**DPIE REQUEST FOR ADVICE – HUNTLEE STAGE 2 – SSD-70748466**

I refer to your request via the NSW Major Projects Planning Portal for advice from Singleton Council on the Environmental Impact Statement and accompanying information for Huntlee Stage 2 - SSD-70748466. Council notes that the due date for submissions was the 19 August 2024.

Surveyor: Andrew David McNamara
 of DALY.SMITH Pty.Ltd.
 Date of Survey:
 Surveyors Ref: 20406 STG 2 DA

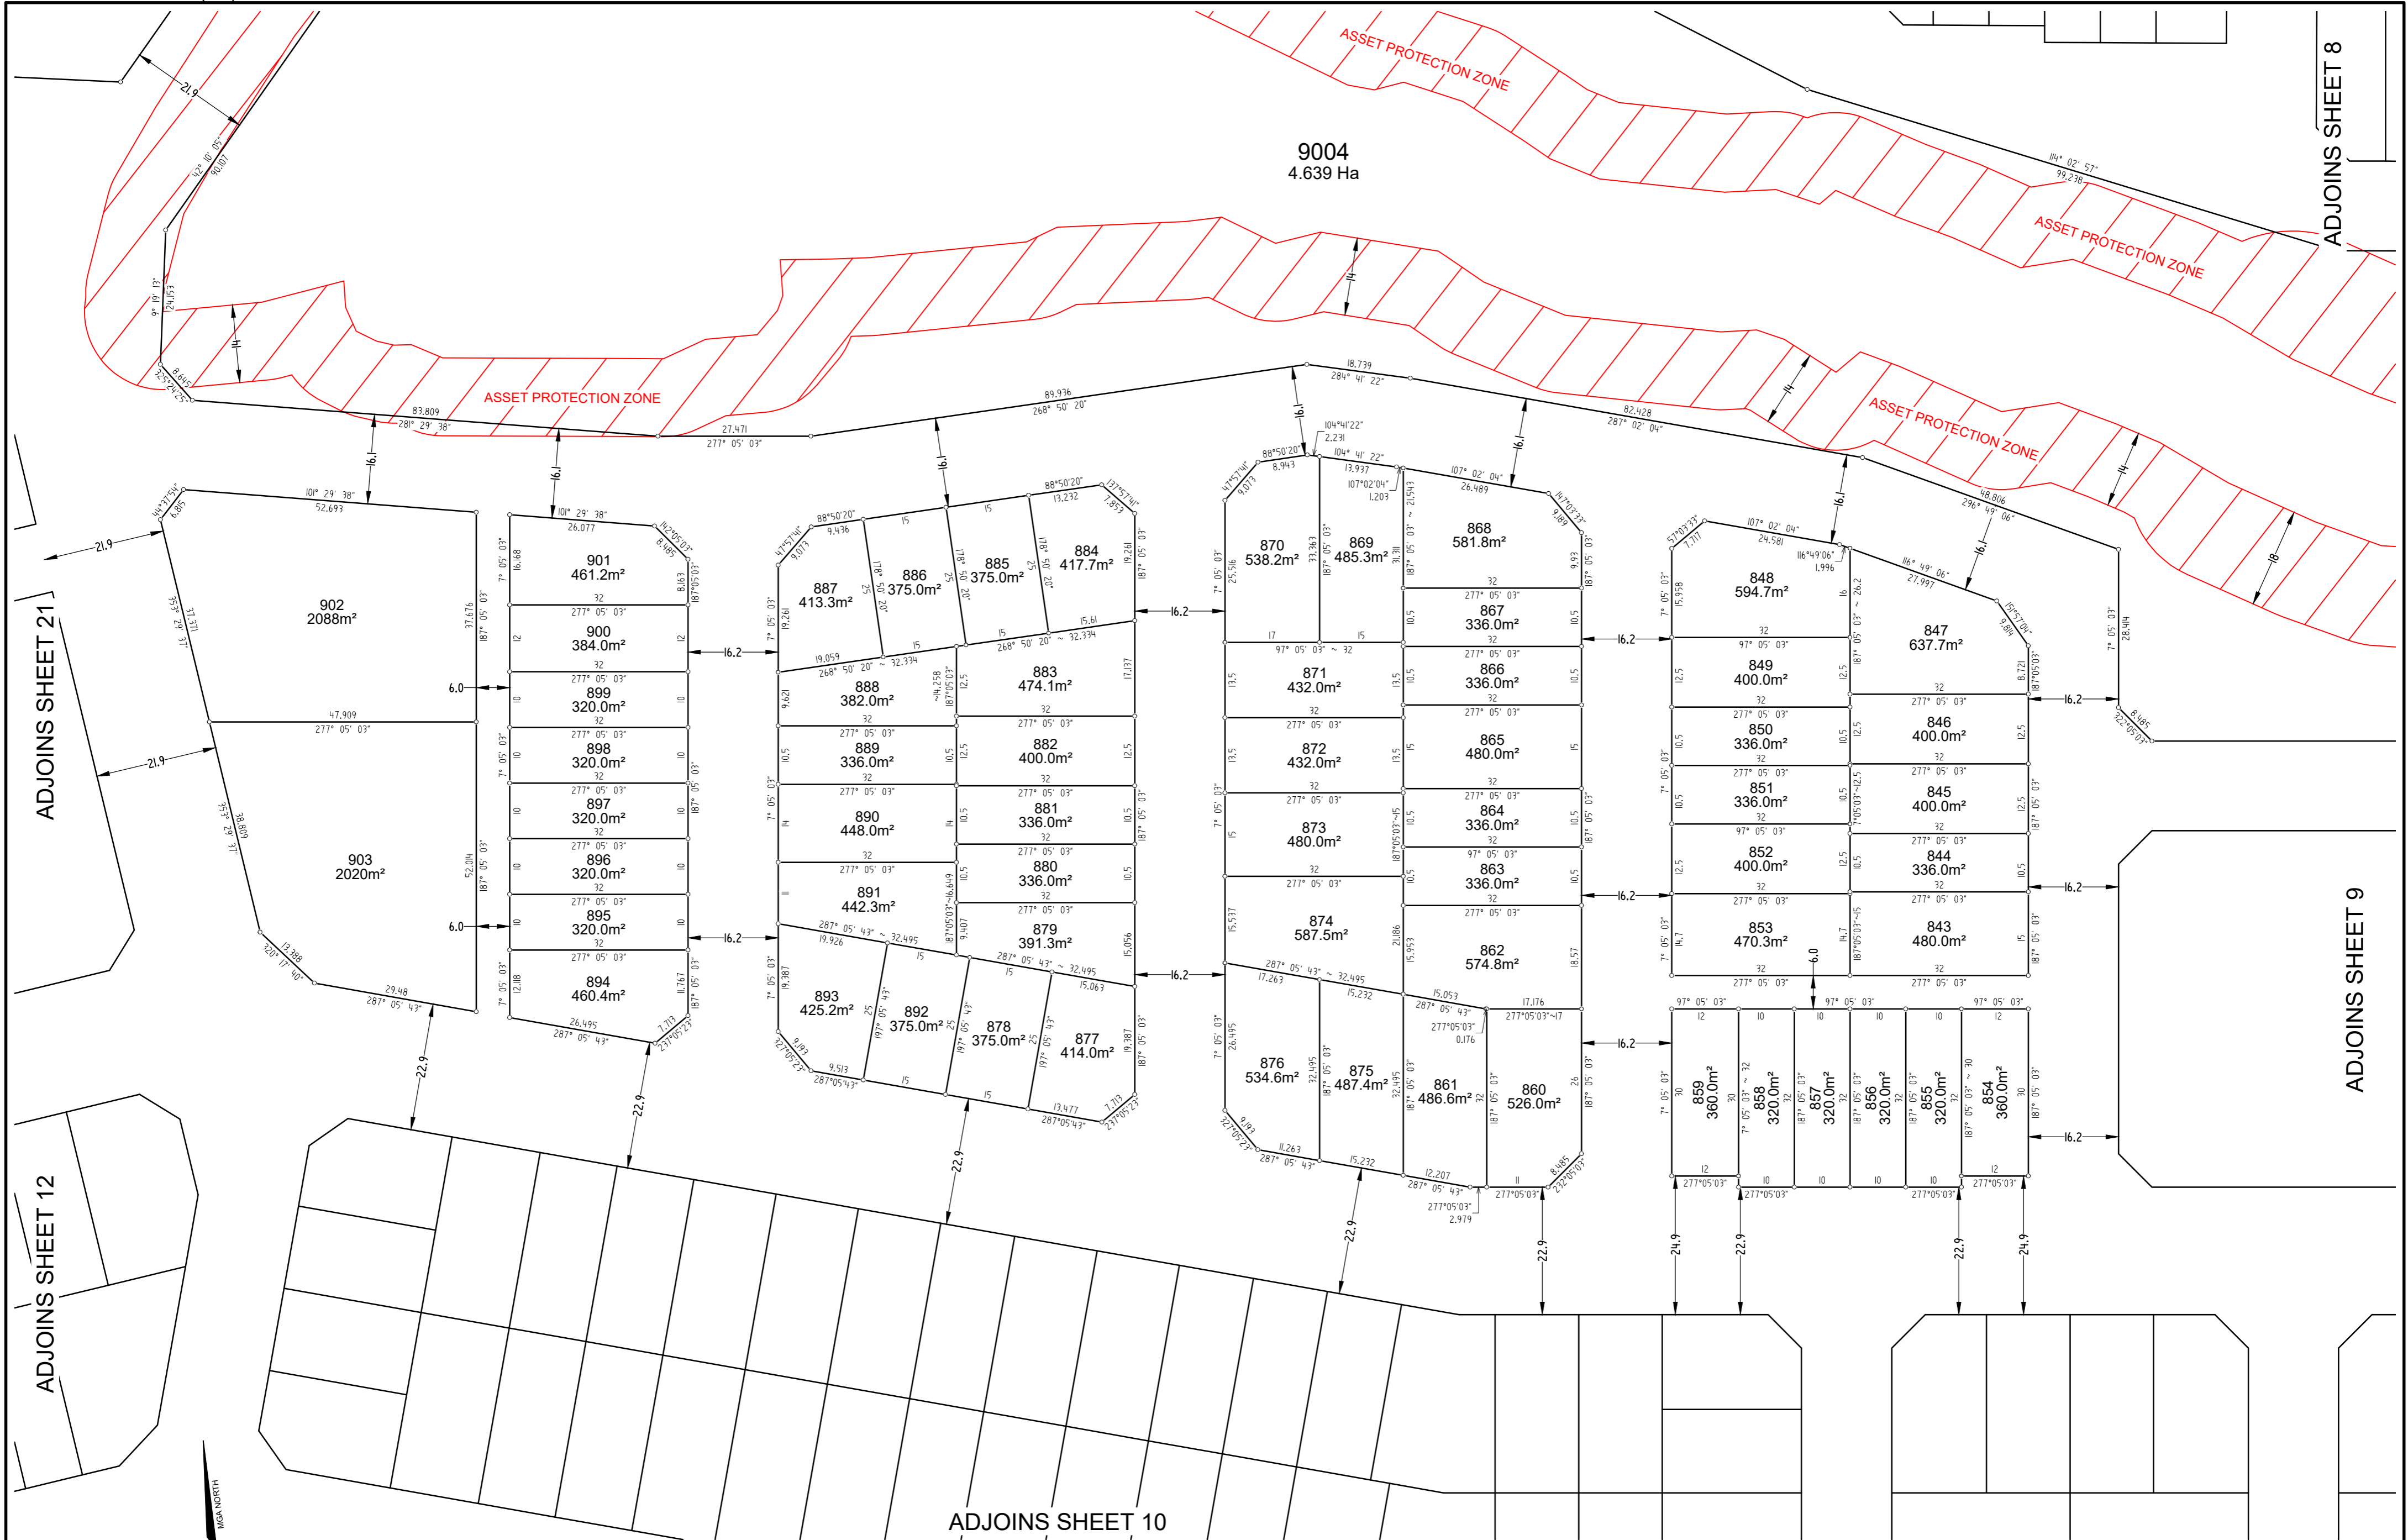
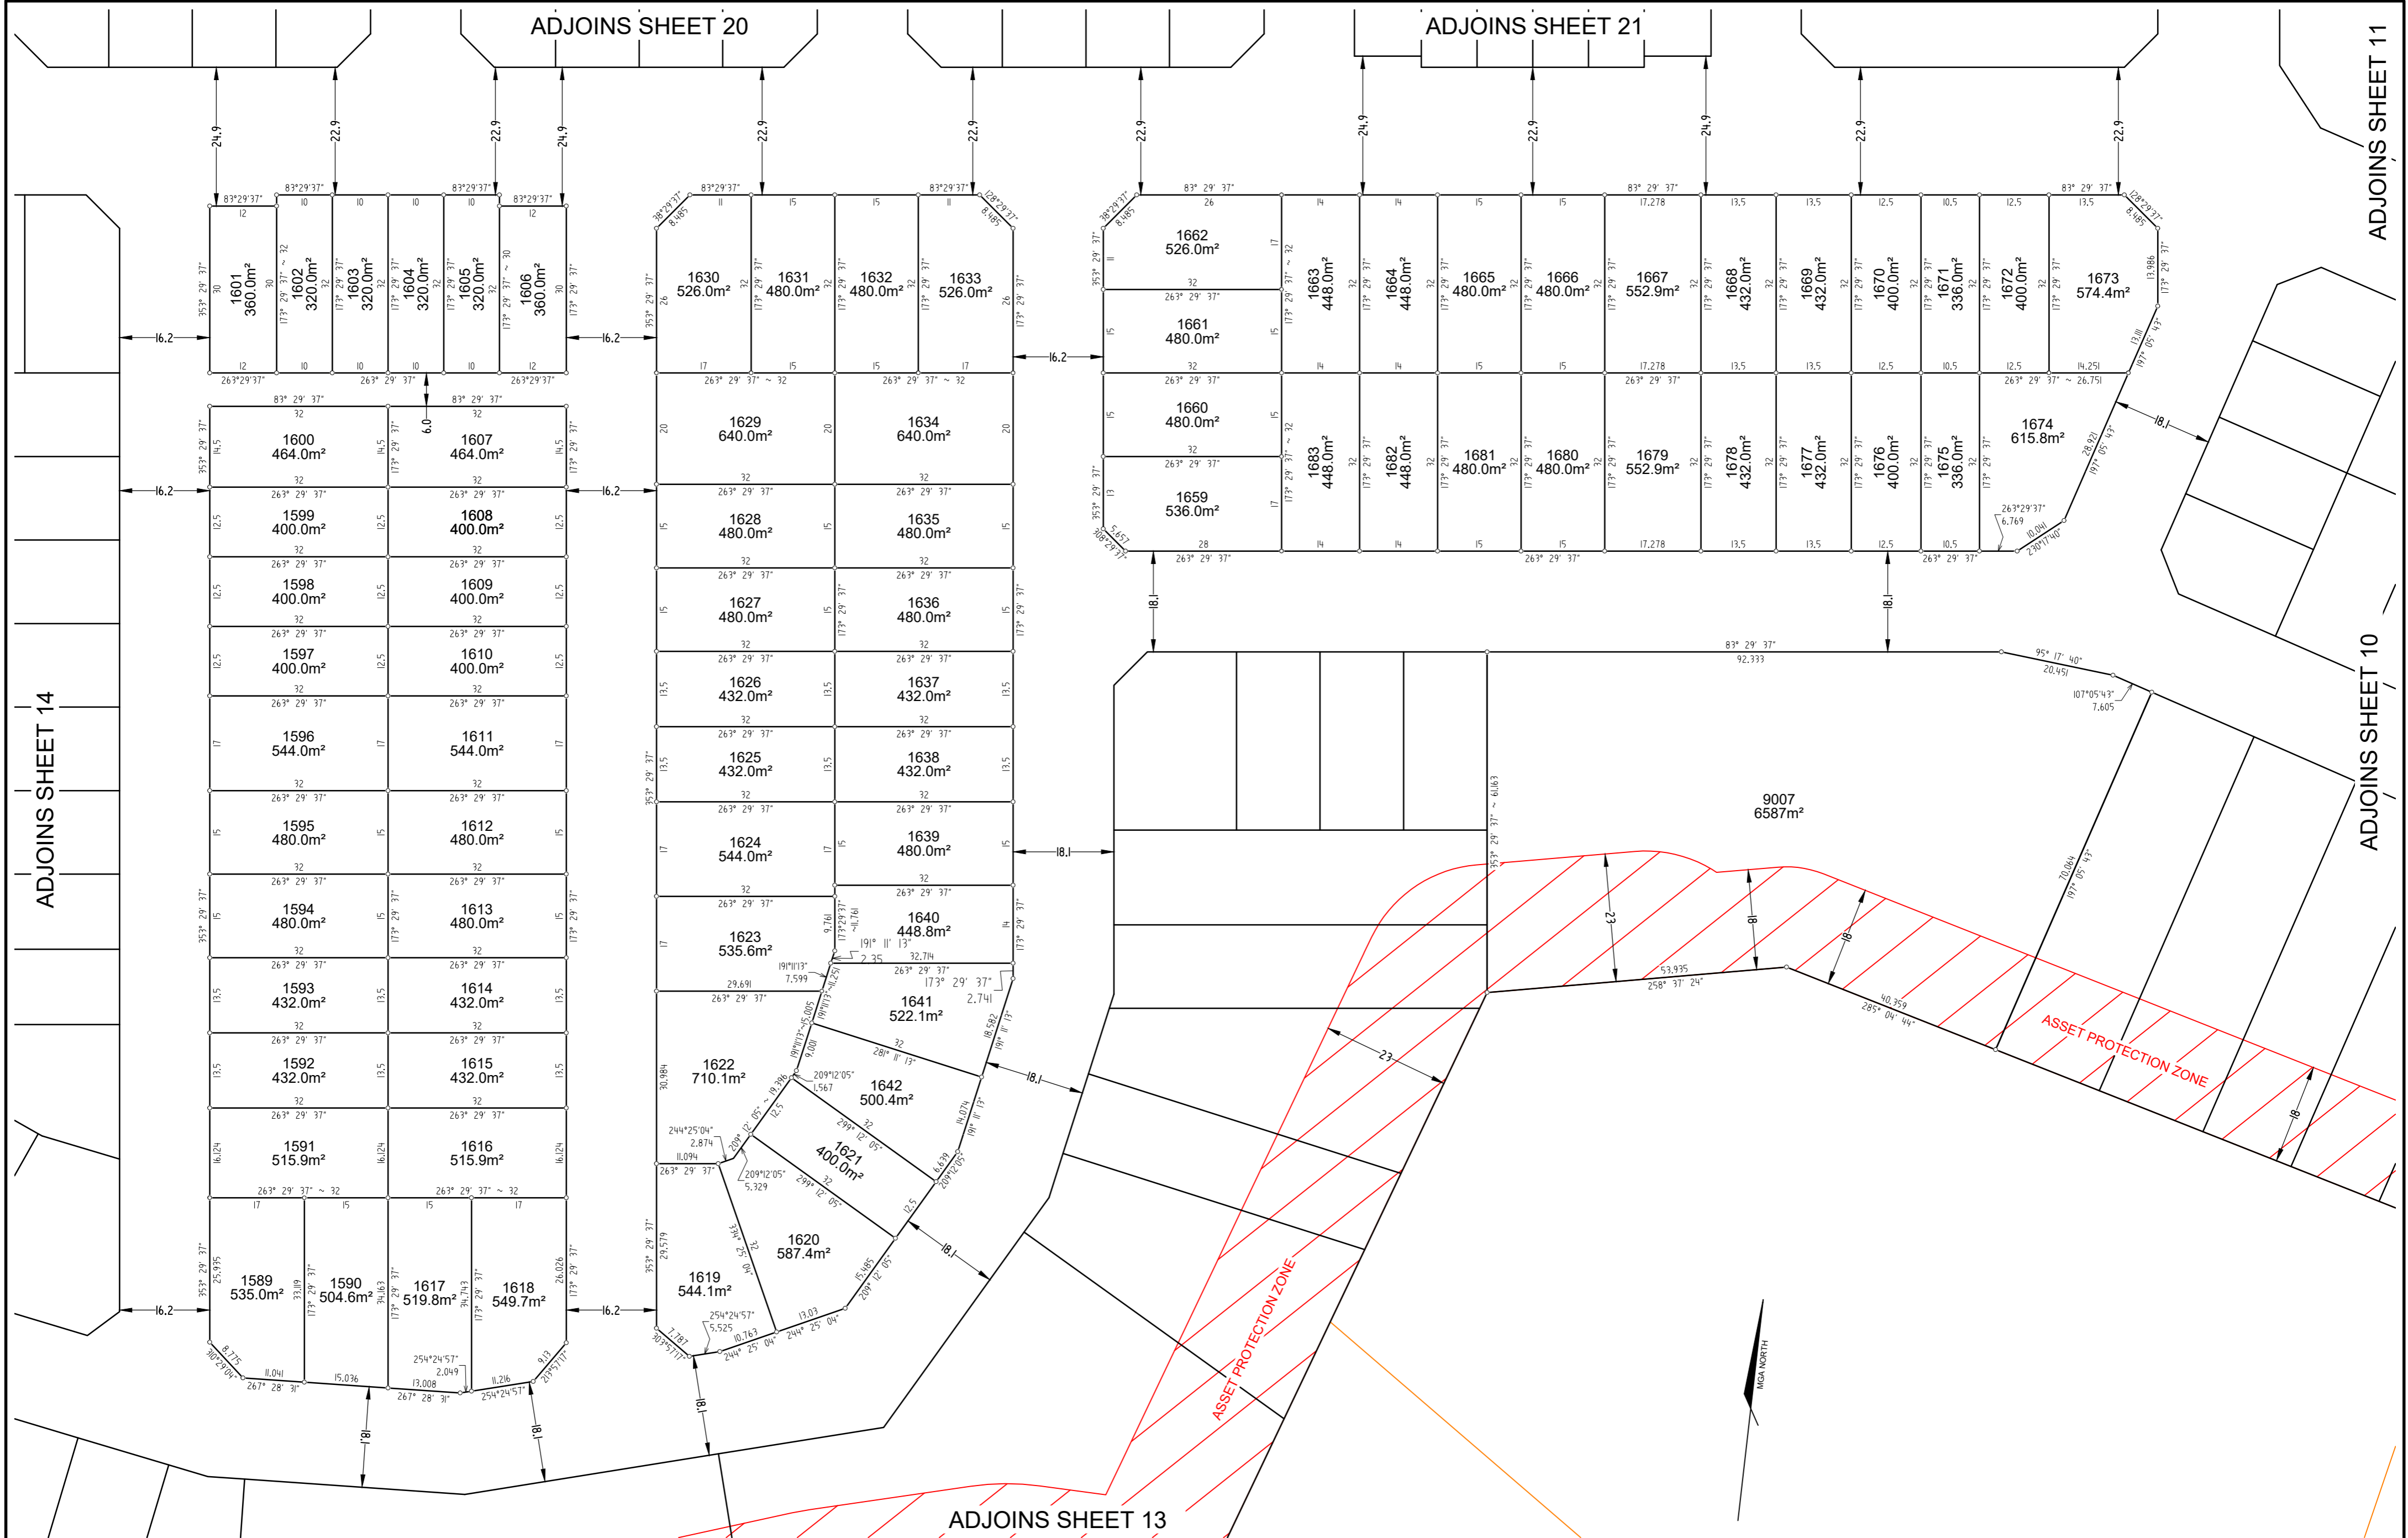
The detailed subdivision plan for Village 2 shows that the Developer is indicating that the proposal will meet targets regarding supplying a range of lot sizes to enable diverse housing. Further detail on the controls that will apply to prevent these larger lots from being further subdivided through modifications. For example, there are approximately 20 medium density lots in Village 2 Centre and South, and it is unclear what controls are in place to stop these being further subdivided into the smaller Cottage lots by either the Developer or future owners of the lot, noting this has happened in Stage 1.

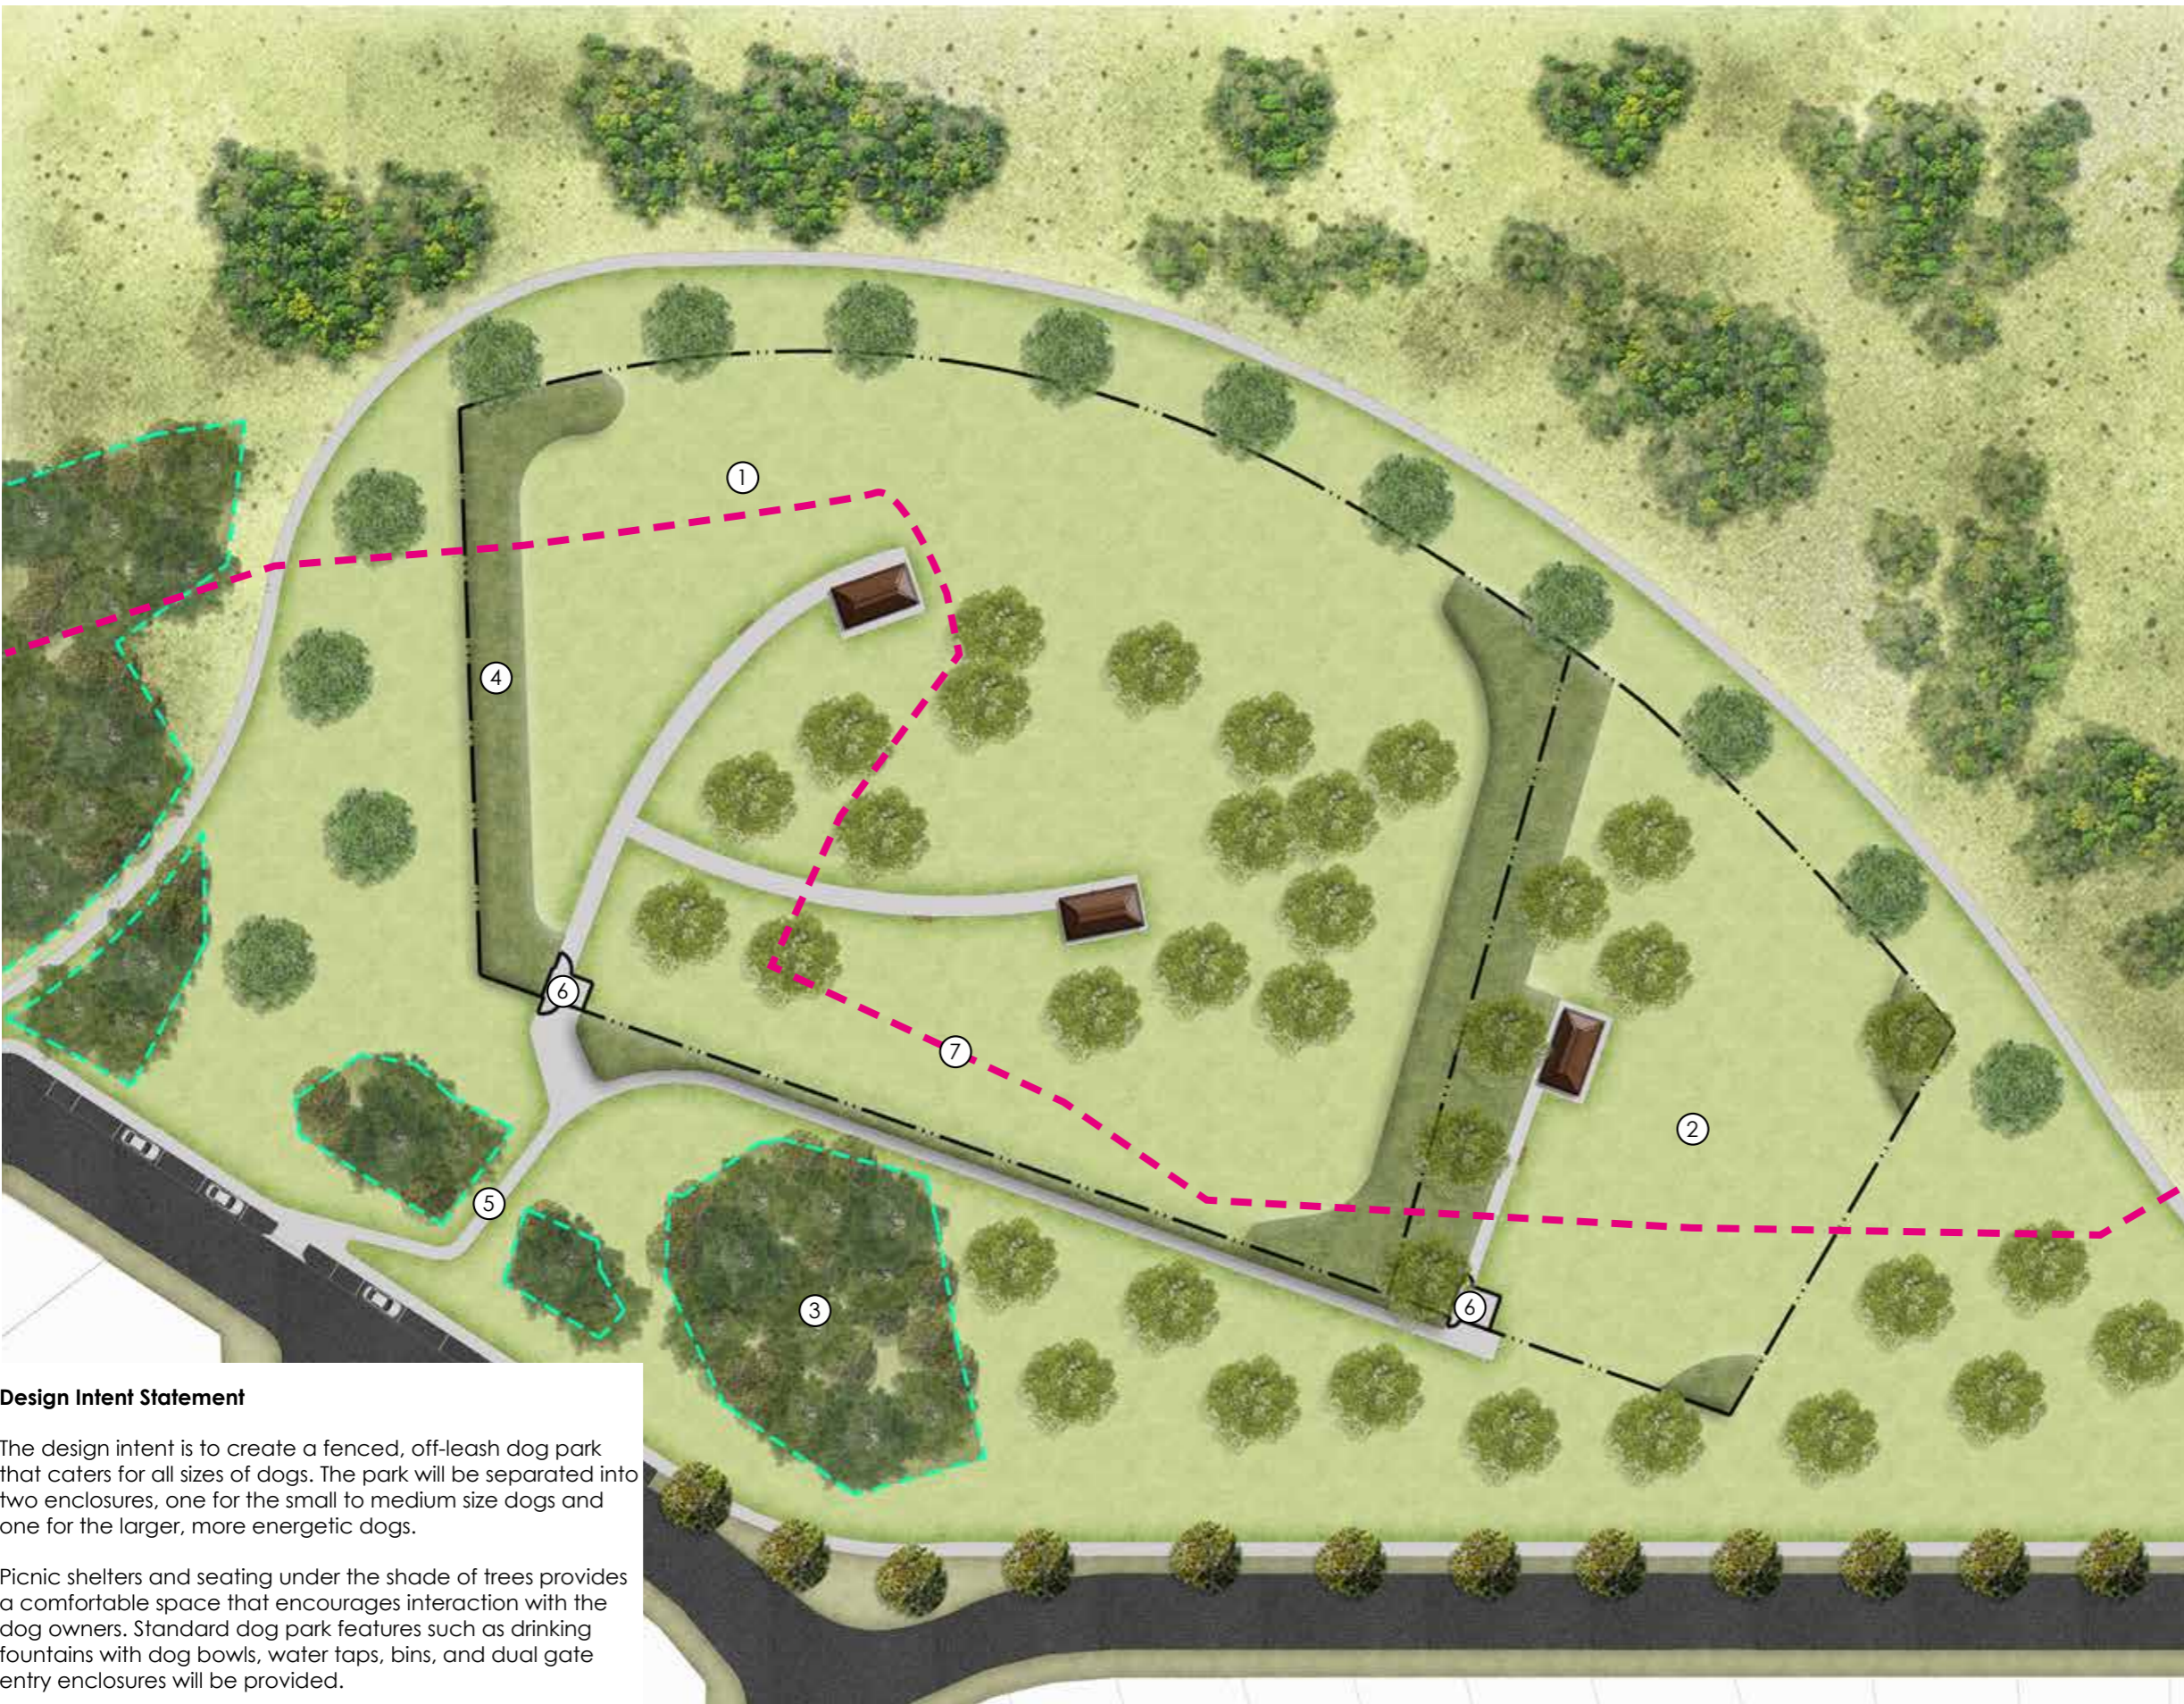
- Remove dog bag holder
- Water fountain to be central to the internal paths
- All tables and seats to be aluminium slats (not timber)
